WEST SUSSEX COUNTY COUNCIL CONSULTATION

TO:	Arun District Council FAO: Mrs A Gardner
FROM:	WSCC - Highways Authority
DATE:	28 April 2020
LOCATION:	Littlehampton Covered Market 26-28 Surrey Street Littlehampton BN17 5BG
SUBJECT:	LU/46/20/PL Demolition of existing building & construction of 1 No retail unit & 3 No. flats with associated external works & access. This application affects the setting of listed buildings & may affect the character & appearance of the River Road, Littlehampton Conservation Area.
DATE OF SITE VISIT:	n/a
RECOMMENDATION:	More Information
S106 CONTRIBUTION TOTAL:	n/a

Figure: Proposed Site Layout

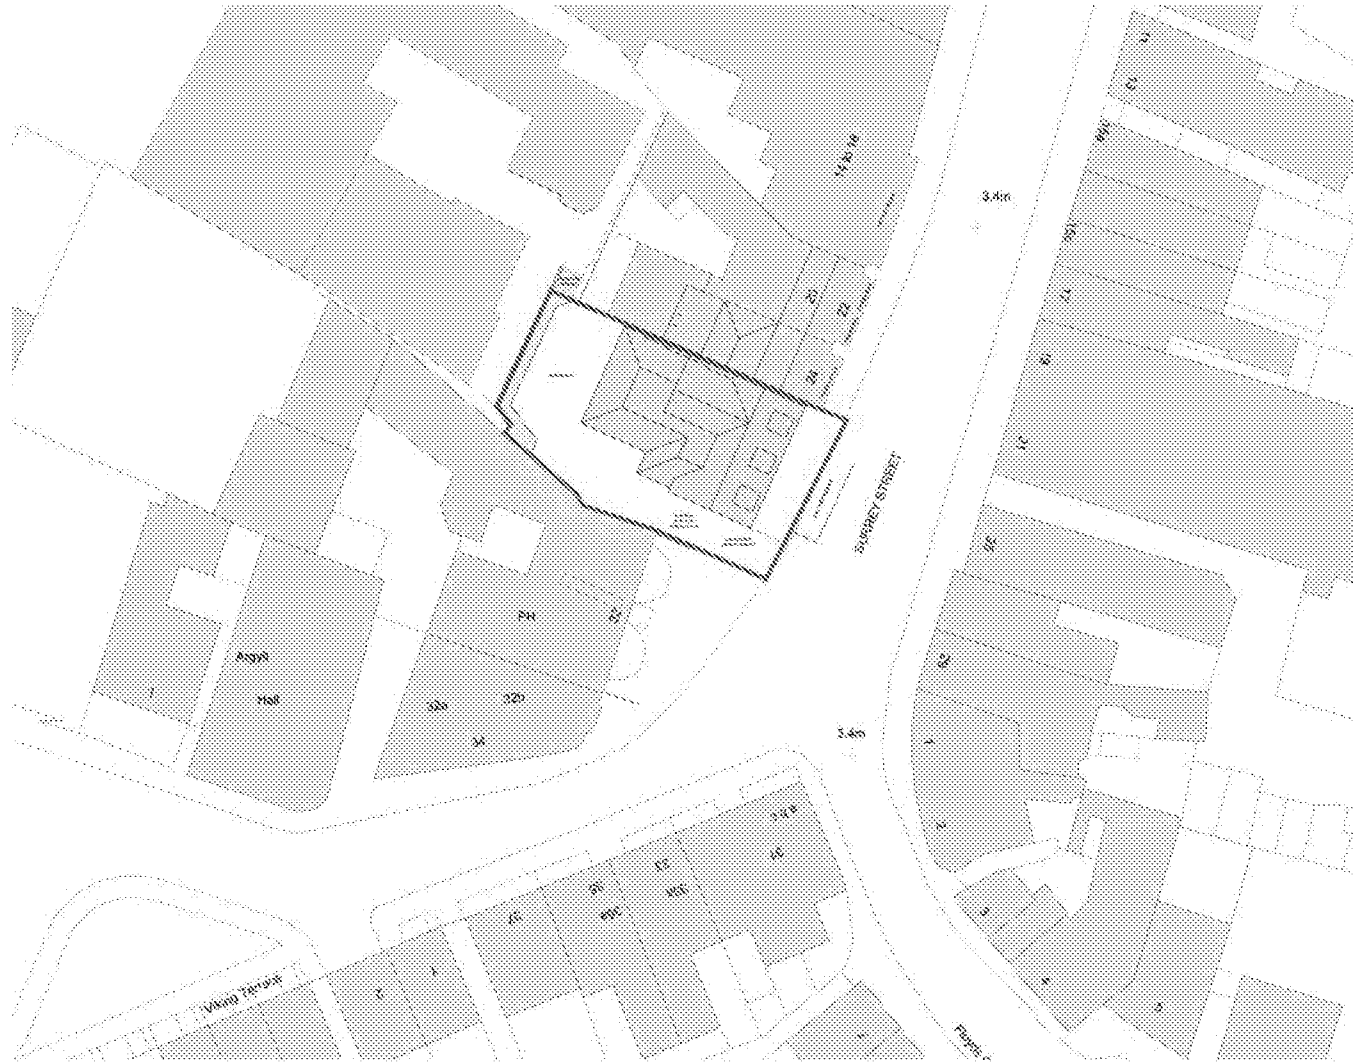
The parking layout has not been demonstrated on the proposed site plan. While the Local Highways Authority would not disagree that three cars could be parked in the parking area indicated it would be difficult to conclude the suitability of this arrangement without seeing the proposed parking layout with spaces marked.

Typically, a space should be provided 6m manoeuvring room to be accessible and facilitate a turn on site. In this situation a multi-point manoeuvre can be used to facilitate access and a turn on site. Depending on the layout of the parking proposed swept path tracking may be required to demonstrate the parking provision could be used for its intended use.

On balance the parking demand for the proposed site as a whole will be significantly less than the existing use. Therefore, it would be difficult to substantiate that any parking implications would result in an unacceptable highway safety concern. However, in order to fully advise on the parking implications a parking layout, and possible swept path tracking, would be required for the residential parking area.

However, in order to fully provide comments pertaining to parking additional information in line with the comments above would be required. At which time suitable wording for conditions can be provided. Based on the plans provided the Local Highways Authority cannot confirm if the flats will be provided with an accessible and usable parking provision if 1 space per flat is provided.
